From: Amanda Scholes on behalf of Planning.Responses
Sent: 21 September 2018 08:17
To: Planning Scanning
Subject: FW: CM/16/18/PL Dementia Care Centre, rear Bairds Farm Shop, Climping, Littlehampton
Attachments: 2868-BCH-ICS-PH1-XX-DR-C-025-P7-S2 - Highway Improvements[4].pdf; Bairds Farm Revised scheme Stage 1 - ICS Designers Response[3].pdf

Subject: CM/16/18/PL Dementia Care Centre, rear Bairds Farm Shop, Climping, Littlehampton

Road Safety Audit Stage 1

Location: Bairds Farm Shop / New Care
Home Access A259 Crookthorn Lane,
Littlehampton
Section 278 Highway works with extra
shared pedestrian/cycle paths

DRAWING TITLE
Highway Improvements

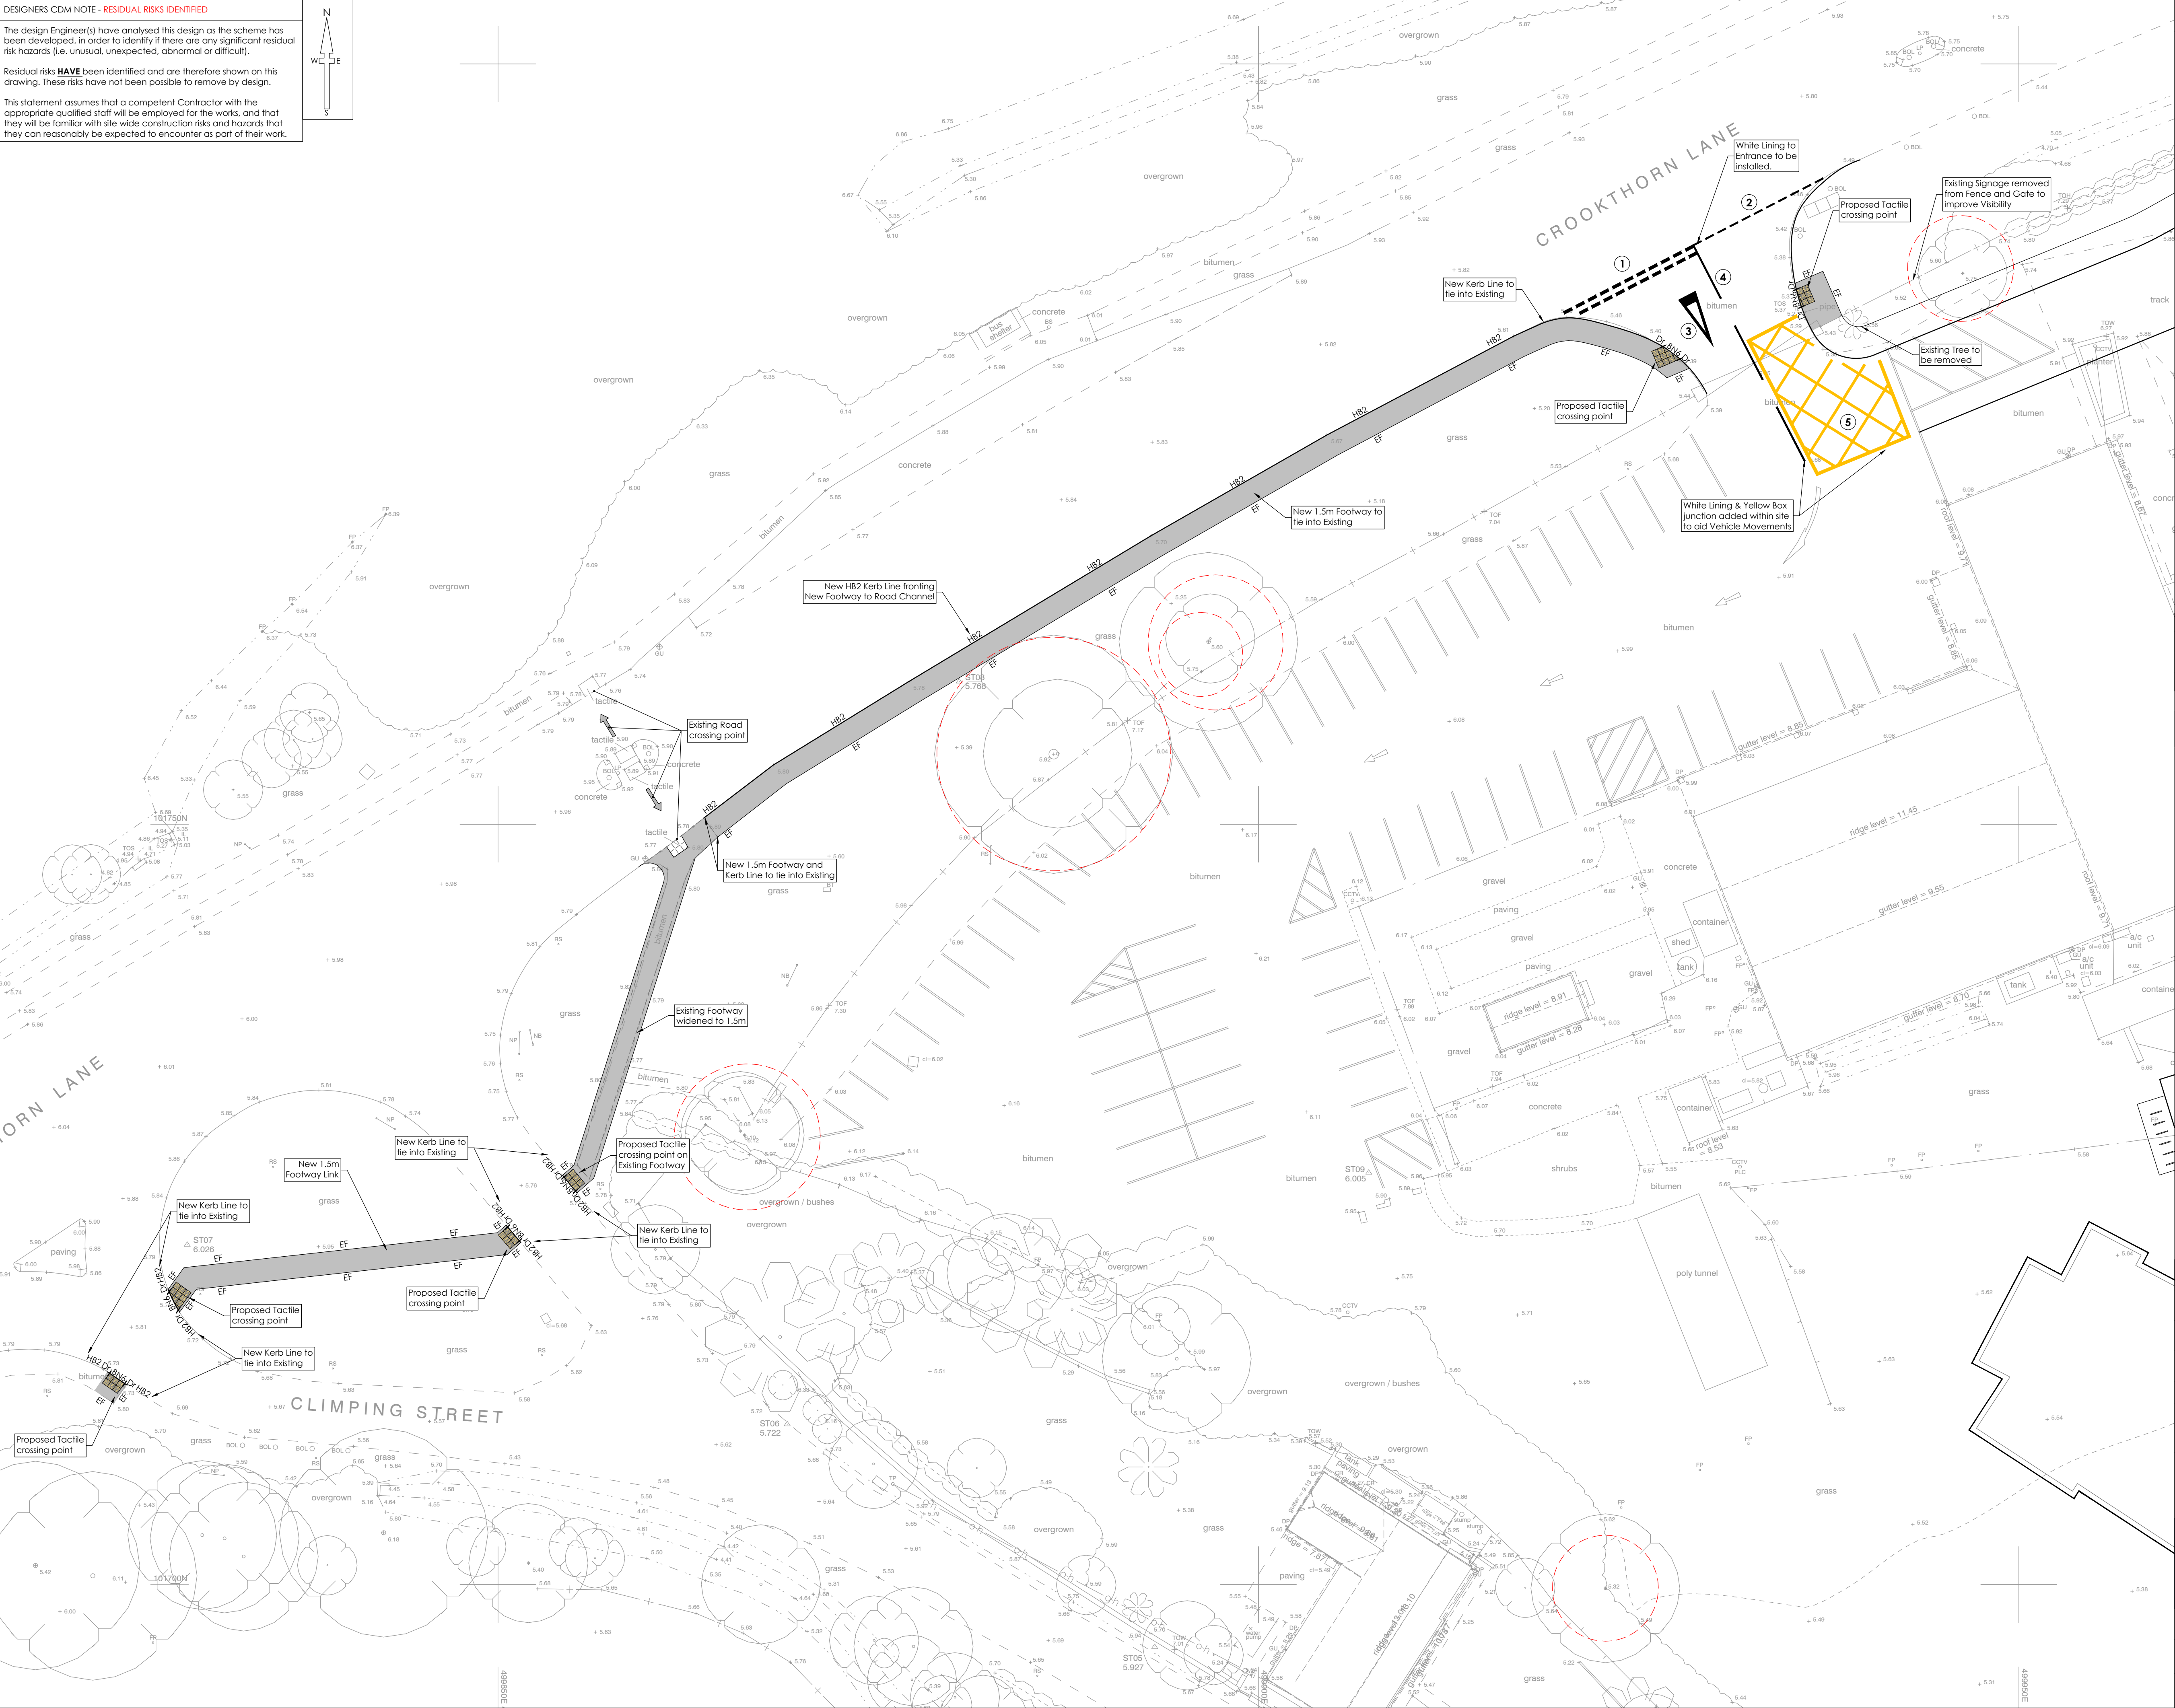
- Problems 8.1 – 8.4 have been addressed by the designer.
 - Problem 8.5 states, Description: A new footway is detailed from the development out onto the A259. There is no central pedestrian refuge island on the A259 to enable pedestrians to cross the road only a central island. This island needs to be changed to a pedestrian refuge and appropriate dropped kerb /tactile paving crossing point provided
Type of conflict/collision: Pedestrians having to cross full height kerbs and stand on central hatching to cross road

Recommendation: Provide appropriate refuge island and crossing point at end of new footway

Therefore the Highway Authority would look for the applicant to address this issue by providing appropriate refuge island and footway to link into the proposed footway adjacent to the site access to provide a continuous footway. A revised drawing should be provided which incorporates these additional highway works and suitably addresses the concern raised by the RSA.

- **Shared Pedestrian/Cycle route** – WSCC Walking & Cycling Officer has requested that the proposed 1.5m pedestrian route to the south of the A259 is amended to be a 3m shared path instead. Given the recent improvements and implementation of cycleway on the northern side of the A259 this will help cyclists who are travelling to

the site travel the majority of their route on bike. Therefore the route could be moved away from being directly adjacent to the A259 and be 3m wide and signed as a shared pedestrian/cycle route.

Once this improvement and the aforementioned pedestrian refuge works are drawn up onto a revised highway works plan it should be shared with the safety auditors for any additional comments.

8.1 *Problem* (item A1.4)

Location: A259 Along new kerblin and new access

Summary: No new drainage detailed to prevent surface water ponding adjacent to new kerblin

Description: A new kerblin is detailed along A259 and at the shop access. This kerblin will cause problems with surface water being retained on the main carriageway. Appropriate drainage needs to be provided at the detailed design stage to prevent ponding on the main carriageway and within the access

Recommendation: Provide appropriate drainage at detailed design stage

8.2 *Problem* (item A 1.12)

Location: A259 between Crossing point at Climping Street and east of Farm shop access

Summary: No cycle path provision to Climping Street or east side of Farm Shop access to crossing point

Description: A new share use cycle path is detailed along the southern side of A259 from the western refuge /crossing point to the Farm Shop. This path does not link upto Climping Street where cycles may be expected to go after crossing the road to head to the beach. There is also no cycle provision for cycles arriving and exiting to go east from the Farm Shop as

only a pedestrian footway is proposed and cyclists will use this path as it is more direct rather than having to go west then cross road and come back on themselves. Provide additional lengths of shared use path

Recommendation: Provide additional lengths of 3m wide shared use cycle paths

8.3 *Problem* (item A4.2)

Location: A259 to rear of proposed path

Description: A new 3m wide path is detailed that will crossfall to the carriageway. There will be a level difference to the rear of the new path that will require the adjacent verge to be regraded to remove hazard to rear of path

Recommendation: Regrade verge to rear of new path

8.4 *Problem* (item A4.2)

Location: A259 Shared use path

Summary: No shared path signs or corduroy paving detailed along shared use path

Description: A new shared use path is detailed with only standard blister tactile paving at the crossing point. Current guidance recommends shared use signs and corduroy paving be installed along shared use paths to ensure pedestrians and those visually impaired are warned of the presence of cycles

Recommendation: Provide appropriate signs /corduroy paving along shared use path

8.5 *Problem* (item A4.3)

Location: A259 Refuge island

Summary: Inadequate size refuge island for cycles to cross

Description: A new shared use path is detailed along the southern side of A259. Cycles will have to use the existing inadequate size refuge island to cross over the road between cycle paths. This island needs to be increased in size to include a minimum of 2m width and 3m length standing area to cater for cycles

Recommendation: Increase size of refuge island to cater for cycles.

8.7 *Problem* (item A5.1)

Location: A259 New pedestrian refuge island

Summary: New island needs to have high level keep left sign to make it more visible

Description: A new refuge island is detailed on the A259 which has a 40mph speed limit with many vehicles travelling faster. The new refuge needs to have high level keep left signs to ensure it is more visible to approaching drivers to avoid collisions (Same as the island it is replacing)

Recommendation: Provide high level keep left signs

Please see attached revised Highway drawing incorporating your requests for a wider footpath and improved crossing points. This has been subjected to a further Safety Audit which, together with our Designers Response, is attached.

8.1	No new drainage detailed to prevent surface water ponding adjacent to new kerbline	The existing carriageway simply drains onto the adjacent verge as there is no formal piped drainage within the area. New proposals seek to replicate this with gullies draining onto the swale depression behind the new footway/cycleway

8.2	No cycle path provision to Climping Street or east side of access to crossing point	Cycle path extended to the west and east
8.3	Level difference to rear of new path	Area to be graded behind the back edge of cycle path

8.4	No shared path signs or corduroy paving detailed along shared use path	Signage and corduroy paving added to the plans. Exact details to be agreed as part of S278 agreements

8.5	Inadequate size refuge island for cycles to cross	Refuge within both islands increased
8.6	Poor surfacing inline of proposed crossing point	No action. Highway maintenance issue

8.7	New island needs to have high level keep left sign to make it more visible	High level keep left sign added to proposals

P7	EPR	TST	Extension of middle island in road, addition of proposed Swales and widening of existing path to allow for shared cycle/footway	14/09/18
P6	ER	TST	Proposed extension of footway/cycleway increased to 3m	31/08/18
P5	SNN	TST	Proposed Crossing Island and Footway extension added site east of entrance	20/08/18
P4	SNN	TST	Proposed Footway amended	30/04/18
P3	SNN	TST	Existing Footway widened to 1.5m	13/04/18
P2	SNN	TST	Junction design amended, Footway Link to the West added	11/04/18
P1	SNN	TST	Initial Issue	28/03/18
REV	DRAWN	CHECK	REVISION COMMENTS	ISSUE DATE
